# Green Hill Solar Farm

## EN010170

### Statement of Common Ground: National Highways Revision A

Document Reference: EX3/GH8.3.7\_A  
Infrastructure Planning (Examination Procedure) Rules 2010

Access to Works Plan

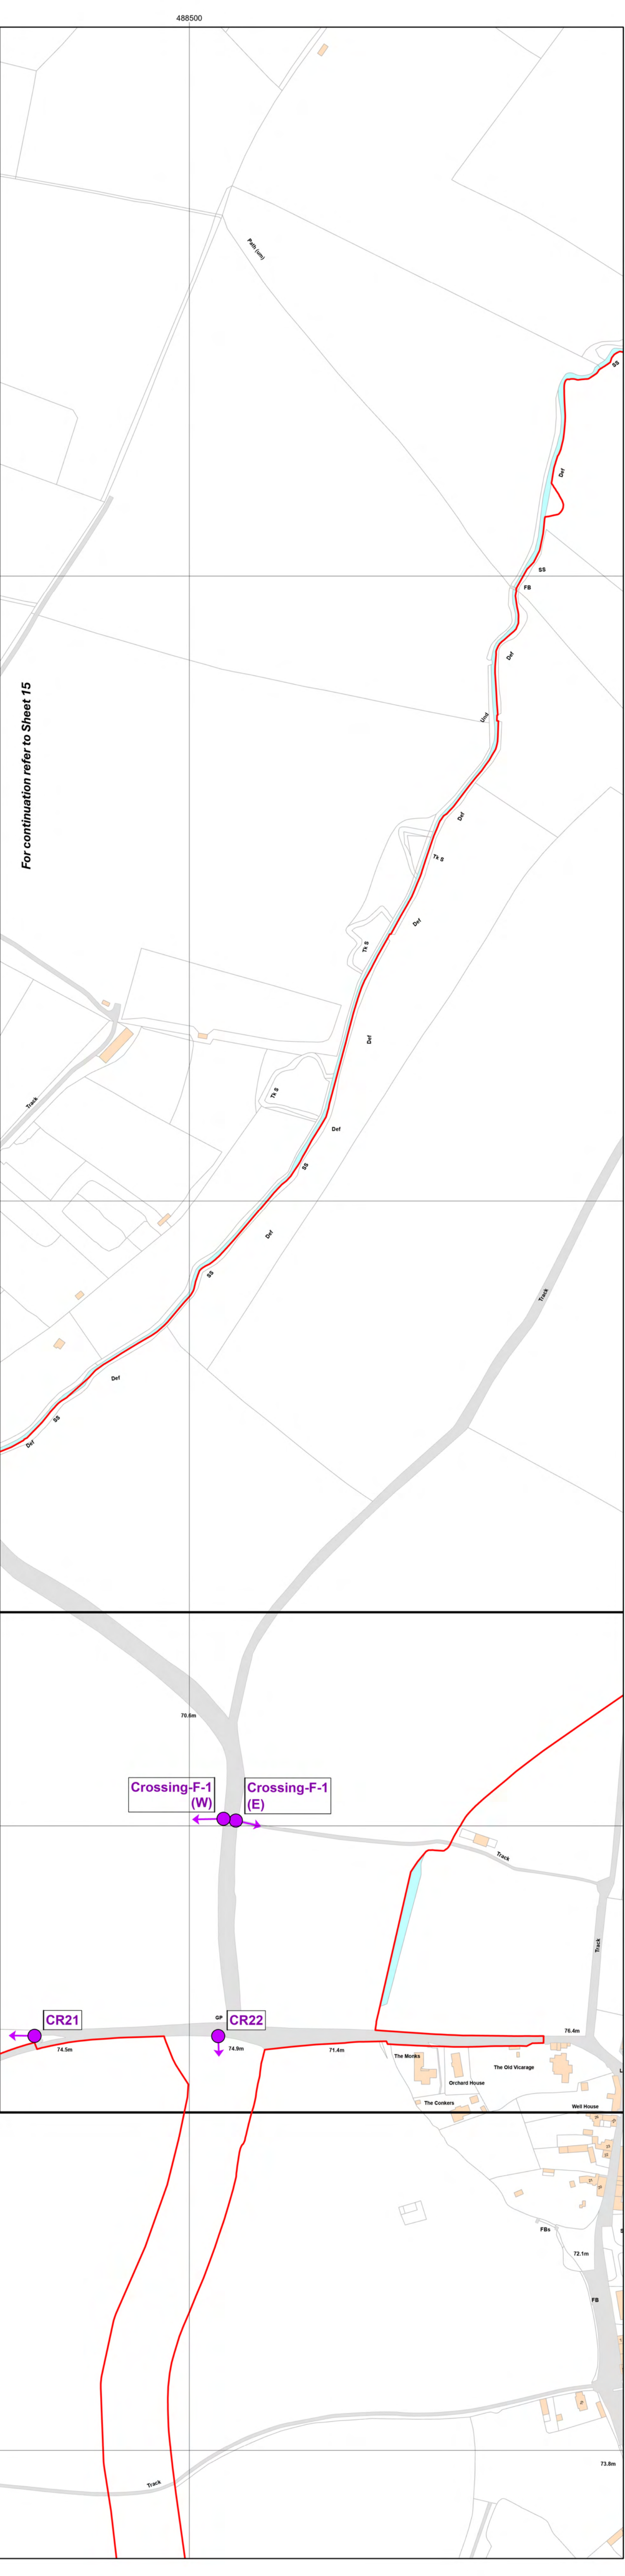
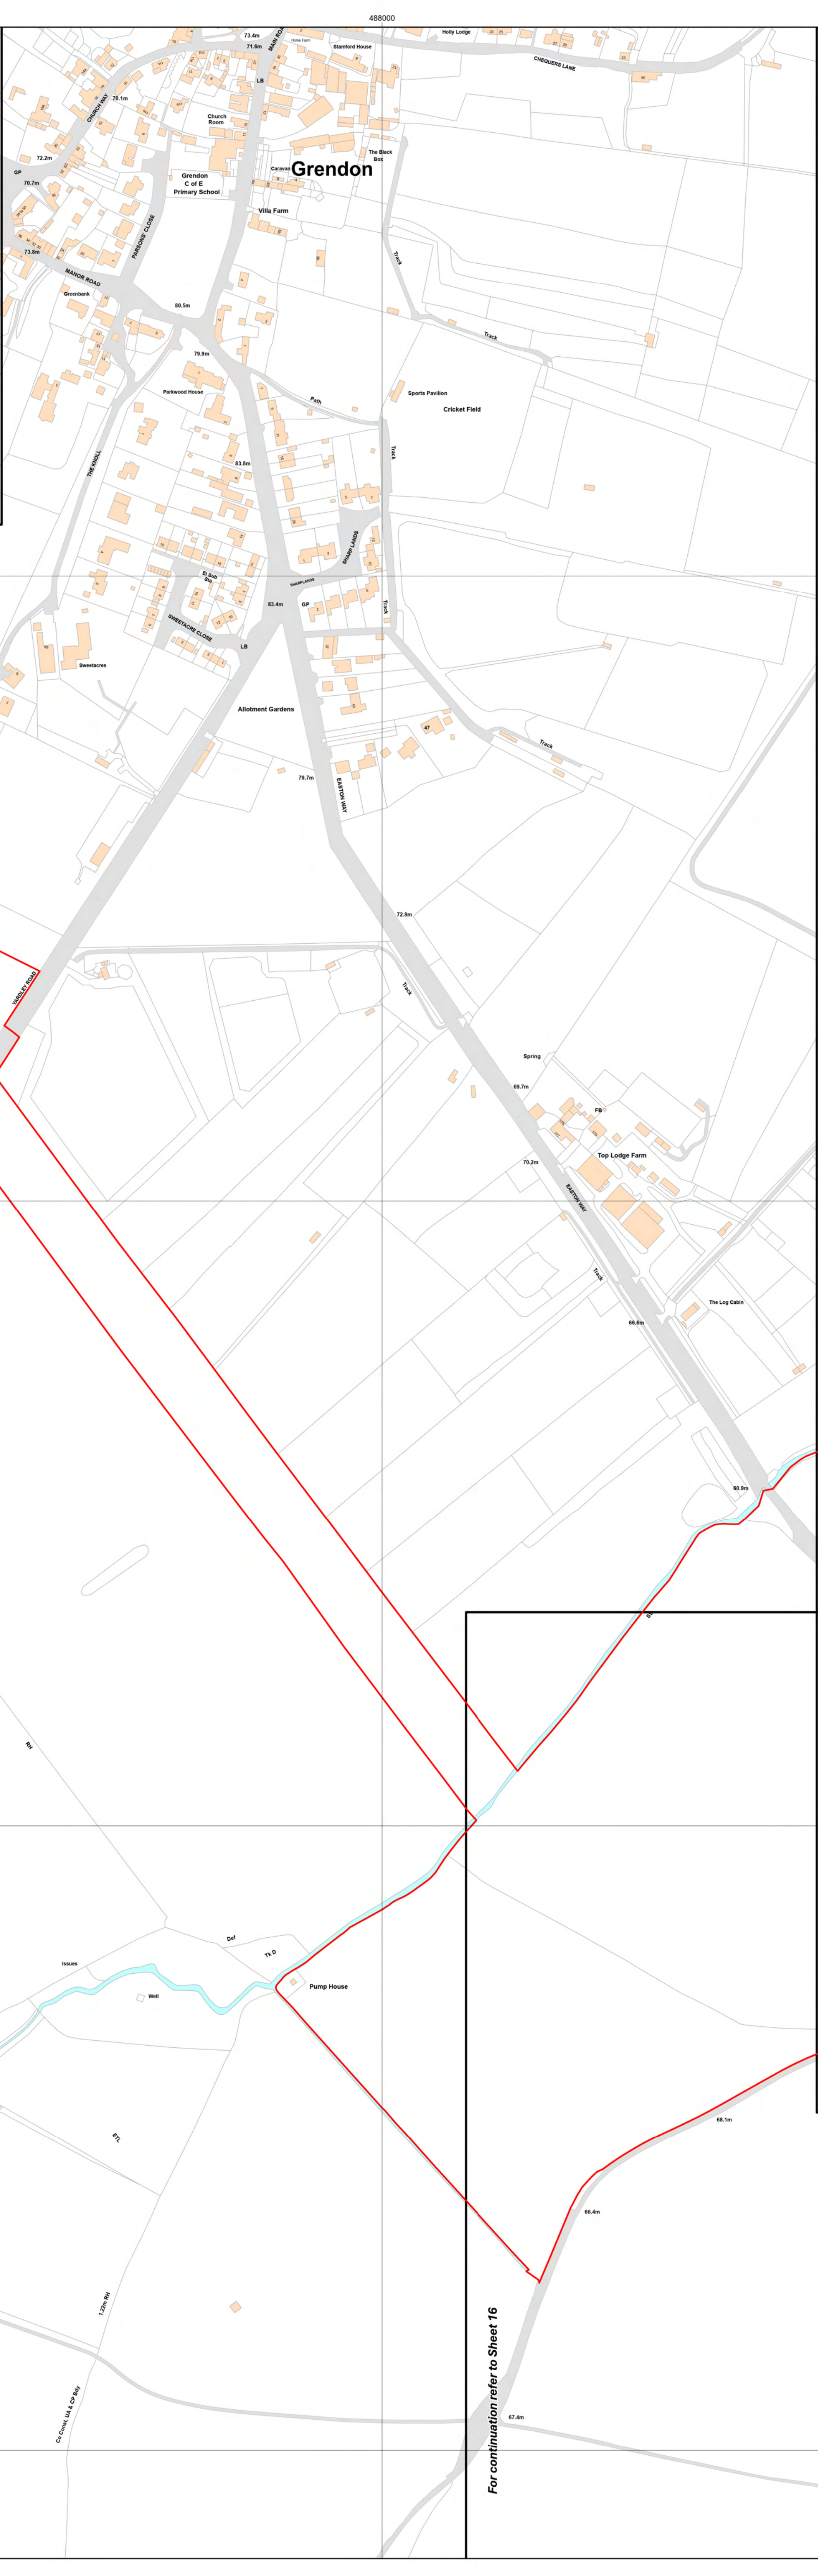
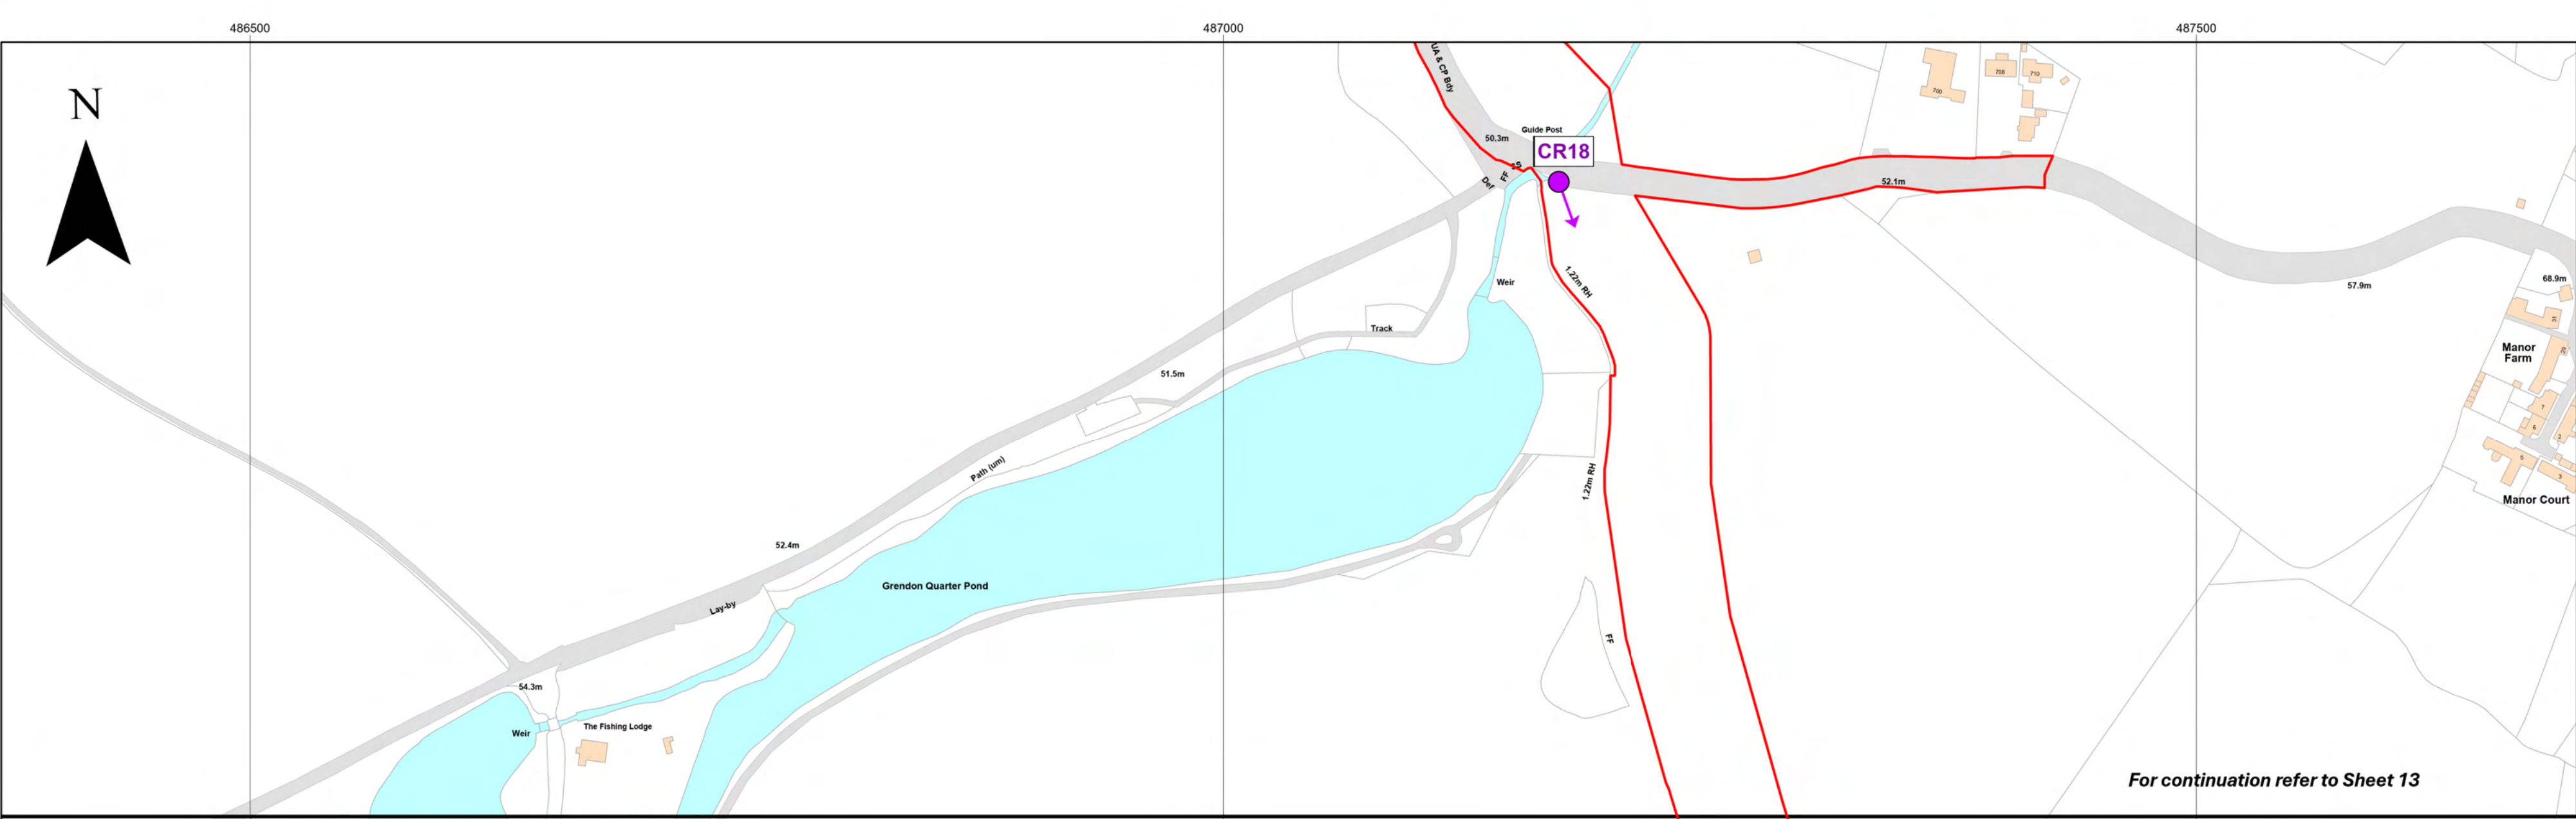
Matter	Details of Matters for Discussion	Applicant Position	Consultee Position	Status	
		complied with in relation to any HDD below the A45.	<p>such disturbance. Cost alone is not an acceptable justification.</p> <p>Details need to be agreed including agreeing the protective provisions with National Highways in order for NH to remove its objection to the scheme.</p> <p><u>Change 7 – Change to Application</u></p> <p>An additional area of approximately 0.12 ha is proposed to be added to the Order Limits. Only the compulsory acquisition of rights (not the land itself) is sought for this area.</p> <p><b>All matters outlined above will continue to apply to the revised Order Limits included within Change 7.</b></p>		
TA-003	Work No. 8A	Works to facilitate those access works at works no 8a will impact the SRN at specific locations due to a need to introduce temporary traffic management on the SRN	Physical works are not proposed in this area. As stated by National Highways, traffic management may be required for periods during the construction. The precise nature of those measures, together with their timing and	Access CR15 marked on the Access to Works Plan (APP-012), located south of the A45 on Grendon Road, and access points CR12 and CR13, also referenced on the Access to Works Plan (APP-012), located off the A45 eastbound slip road	Matter under discussion
